Application: SSI 7485

I write regarding the proposed modification to M4-M5 Link, Mod 2 The Crescent overpass and changes to pedestrian infrastructure in North Annandale, Rozelle and Rozelle Bay Foreshore area.

**Figure 4 | Proposed modification** (Source: Design Amendment Report)

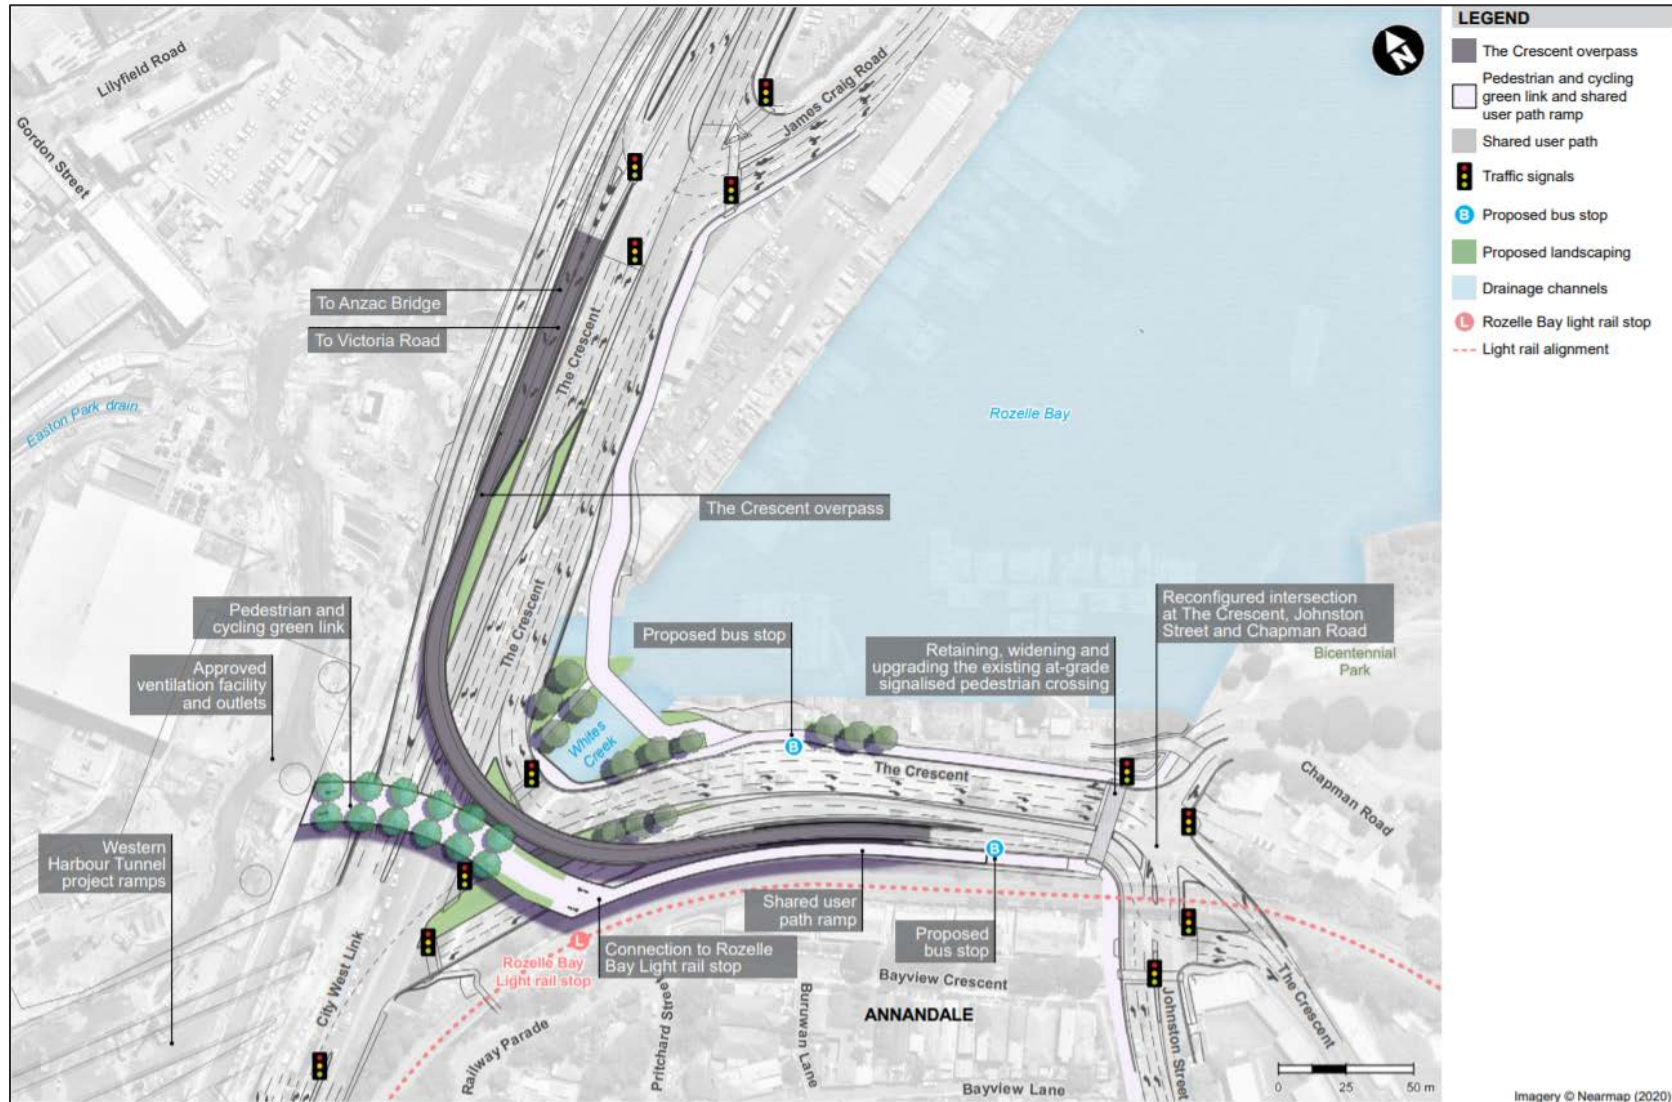
I request RMS work with the community to explore alternate design options to the proposed new car overpass design and the changed pedestrian and cyclist links. I am seeking the reinstatement of the safe, direct access from the approved EIS GreenLink to create a continuous green open space connection from the Rozelle Rail yards and Annandale to the foreshore. The GreenLink was more than just a walk way - it put people central to the design, maximising safety, and providing much needed accessible open space for the community now and into the future Bays Precinct design.

- The significantly reduced safety and increased risk for pedestrians and cyclists with removed access over The Crescent to Bicentennial Park and the increased traffic along Johnson Street.
- Being required to cross five sets of pedestrian lights at The Crescent as my option to reach the foreshore from Annandale or from Rozelle light rail stop.
- Removal of direct active links to the foreshore, cutting the community off from the area and the proposed revitalisation of the entire Bays Precinct, including linking the Light Rail and Bus stops to a Ferry wharf and Metro station.
- Urban and landscape design that is being built before a finalised Masterplan for the area.
- Traffic changes that limit movements around the suburb and create further congestion in the local streets of Annandale, Forest Lodge, Glebe, Lilyfield and Rozelle with no planning to deal with these.

- Reinststate the GreenLink connecting communities and green open space from Rozelle to Bicentennial Park.
- Relocate and design pedestrian and cyclist connections that are continuous, safe and direct.
- Design the modification infrastructure and active links in response to the character of the suburbs, the location of the foreshore and it's potential future development.
- Provide pedestrian and cyclist paths that maximise people safety and do not force us onto busier streets, unsafe concrete plazas and caged walkways.
- Integrate active and direct connections to all active transport – including the future Metro West and Foreshore Ferry Wharf.
